25 Cottage St
Project Name/Description

**CITY OF PORTLAND, MAINE
DEVELOPMENT REVIEW APPLICATION
PLANNING DEPARTMENT PROCESSING FORM
ADDENDUM**

RE: Application for single family house, Ashmont Street/Cottage Street

Upon review of the site plan, the City's Planning Division has the following comments:

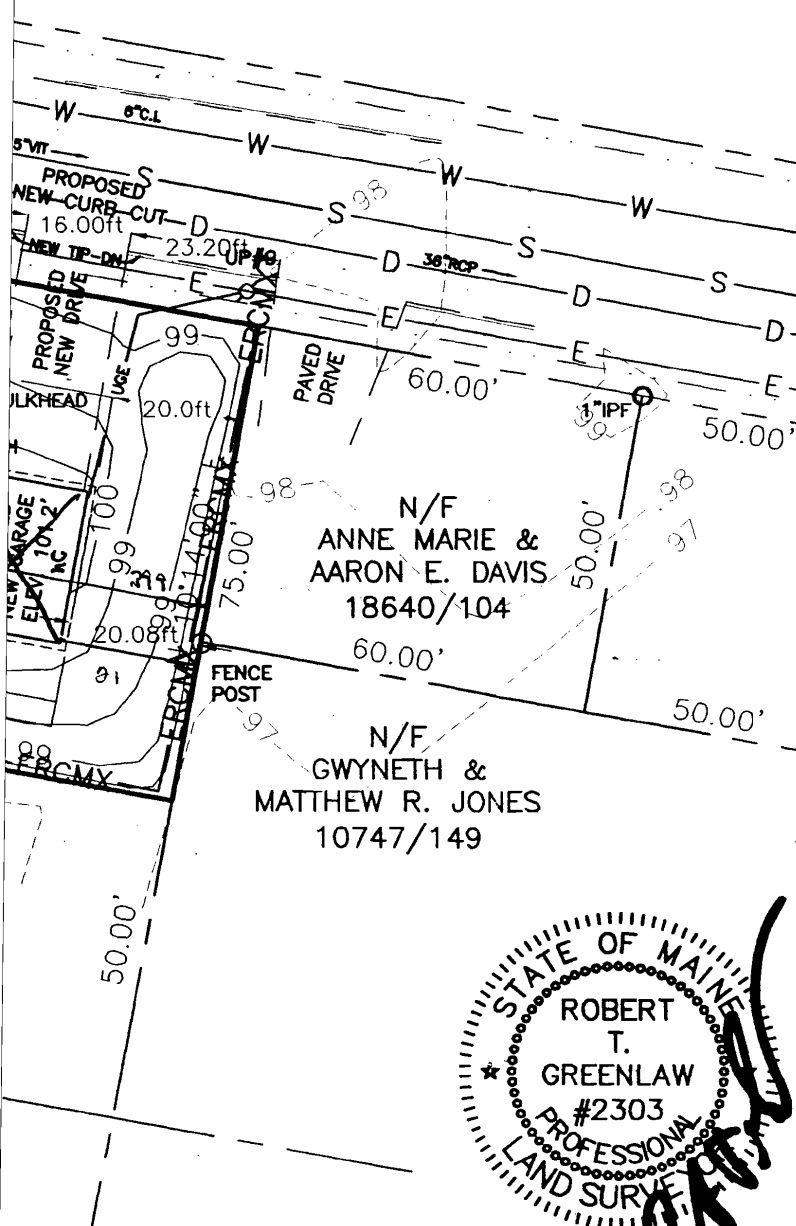
1. Please revise your site plan to show what is actually being built. I understand that you have modified your design and have added porches and removed the garage and bulkhead.
2. Please add a storm drain/field inlet pipe to your site plan. There is a storm drain system that it could be tied into within Ashmont Street. Currently your lot is designed so that you will have a foot of standing water along your side boundary line. This drainage needs an outlet.
3. Please add 2 street trees (required for single family development, to be installed along the street frontage of the property) to your site plan.
